Ref: 6/2021/1508/HOUSE
Date: 10/08/2021

HISTORIC BUILDINGS AND CONSERVATION ADVICE

RE: *Just House, Coopers Lane, Northaw, Potters Bar, EN6 4NJ*

The application is for the installation of an external swimming pool.

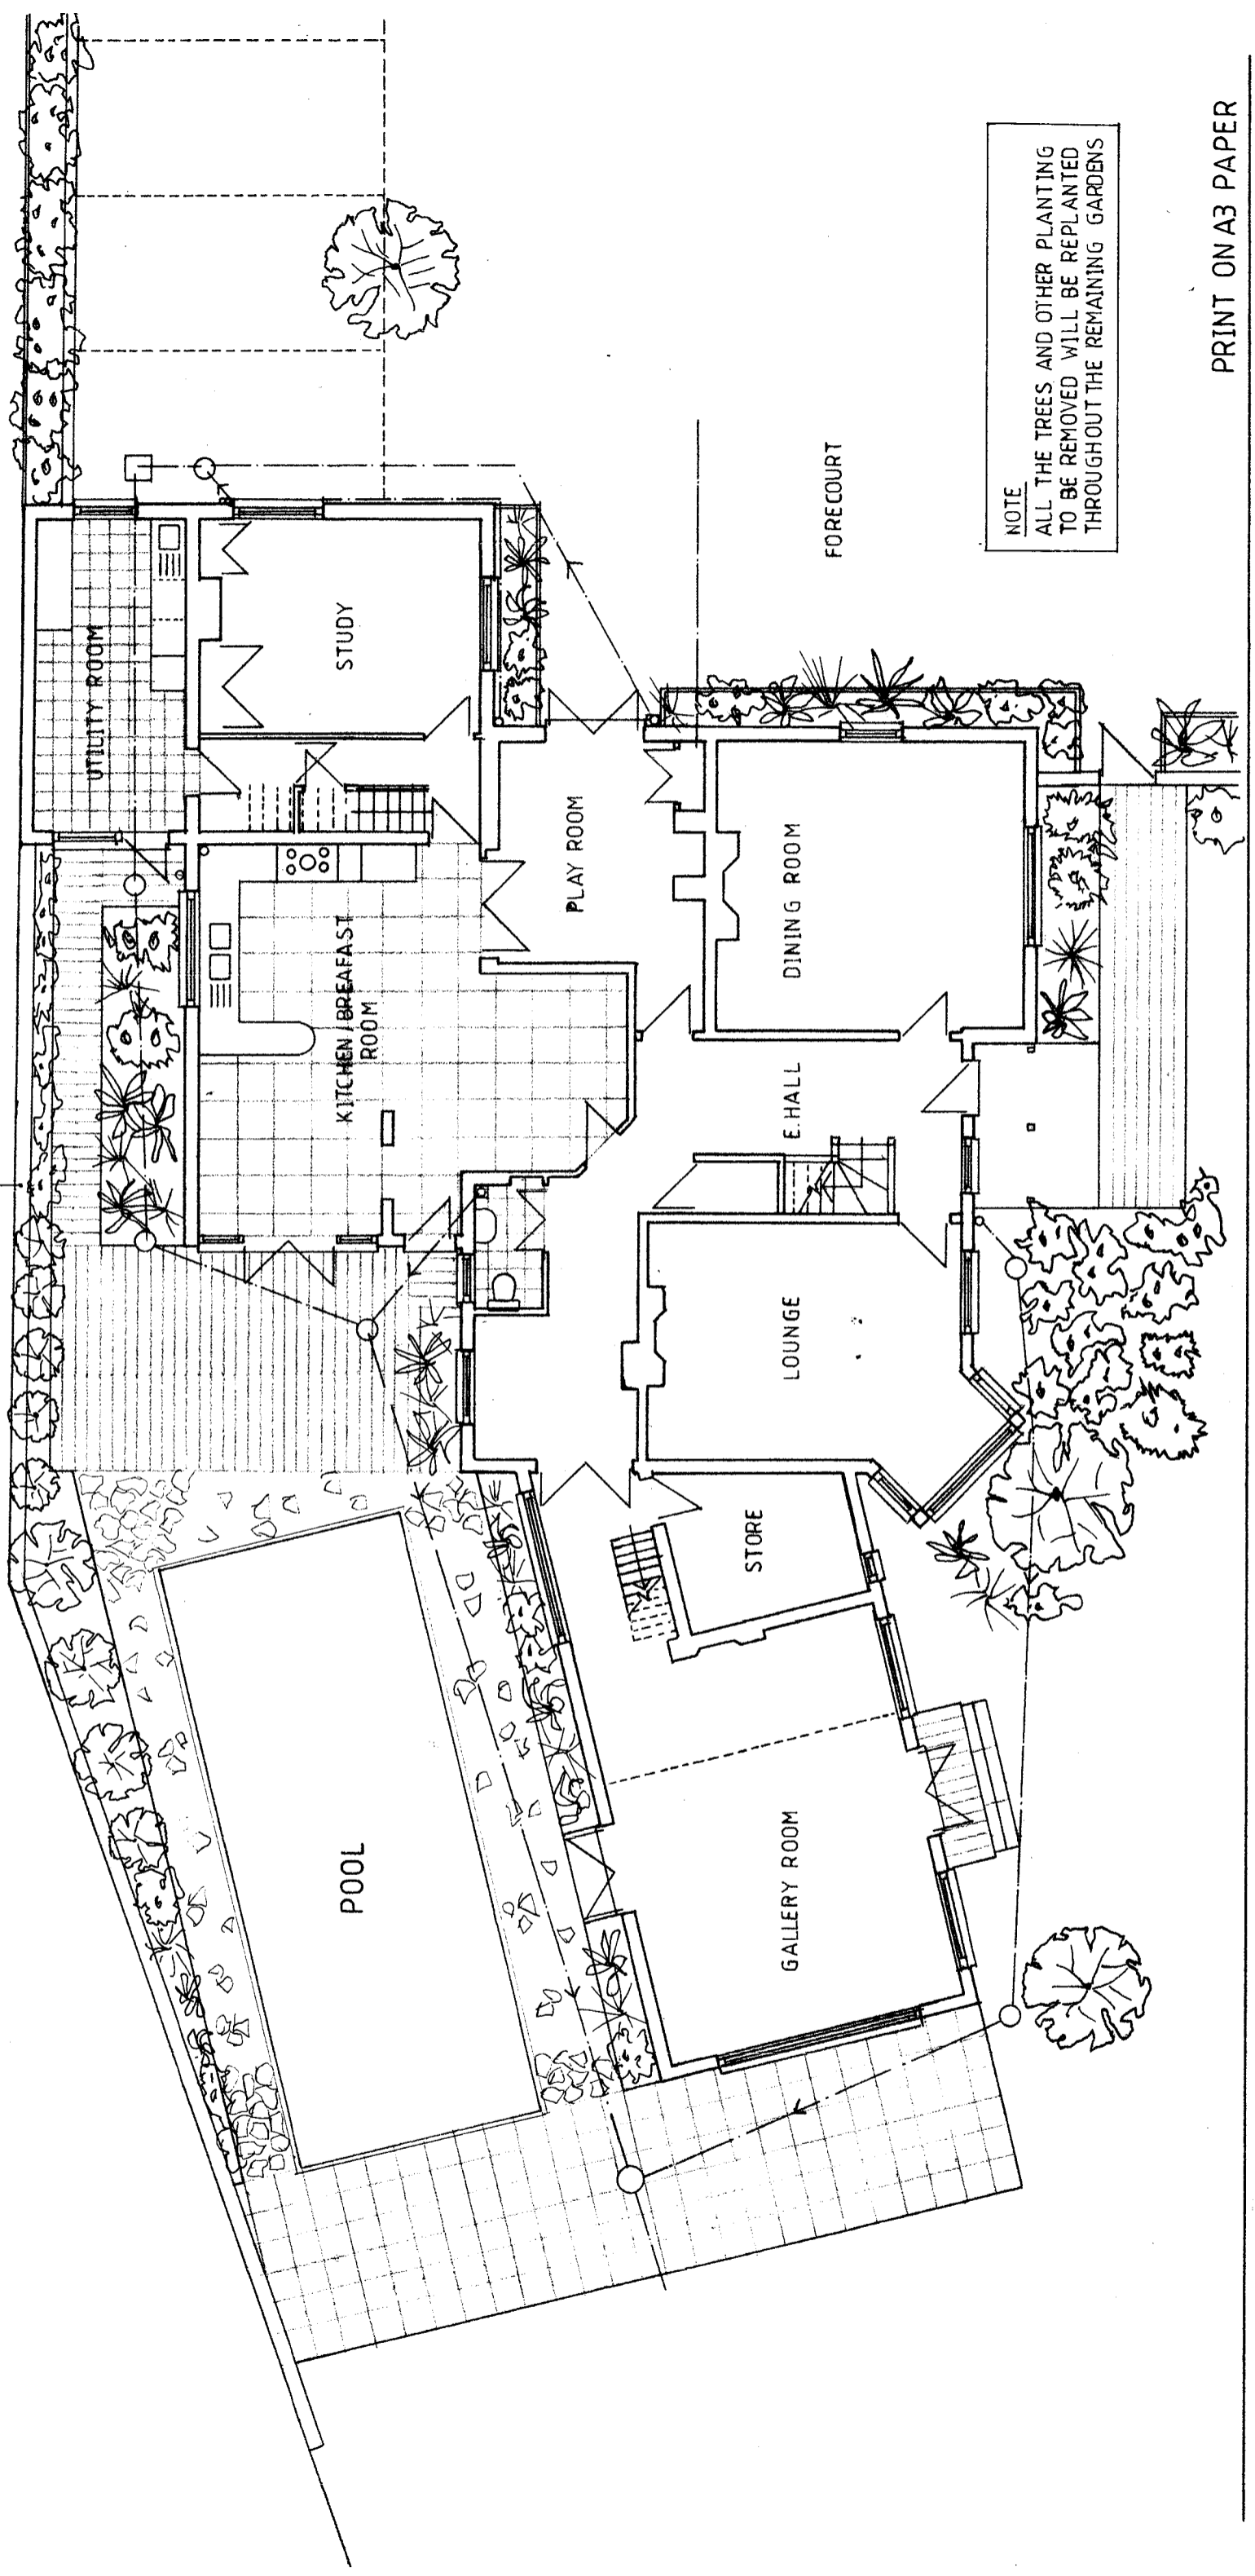
The rural character of the area makes a positive contribution to the settings of the listed buildings. It is noted that the existing trees and planting will be removed to accommodate the pool (drawing no. AR/A3/006A). As the pool is adjacent to the boundary with Spinney Cottage it is recommended that planting/hedging is included along the boundary. Some planting is shown on the proposed ground floor plan (drawing no. AR/A3/006A) and further details can be reserved by condition.

There are no objections in principle to the installation of an outdoor pool as it is not considered to be detrimental to the settings of any of the nearby listed buildings and will not harm their significance, in accordance with Section 16 of the NPPF (2021) and Section 66(1) of the Planning (Listed Buildings and Conservation Areas) Act 1990. As noted above, planting along the boundary would better preserve the rural character of the setting of Spinney Cottage and it is recommended that a soft landscaping scheme is reserved by condition.
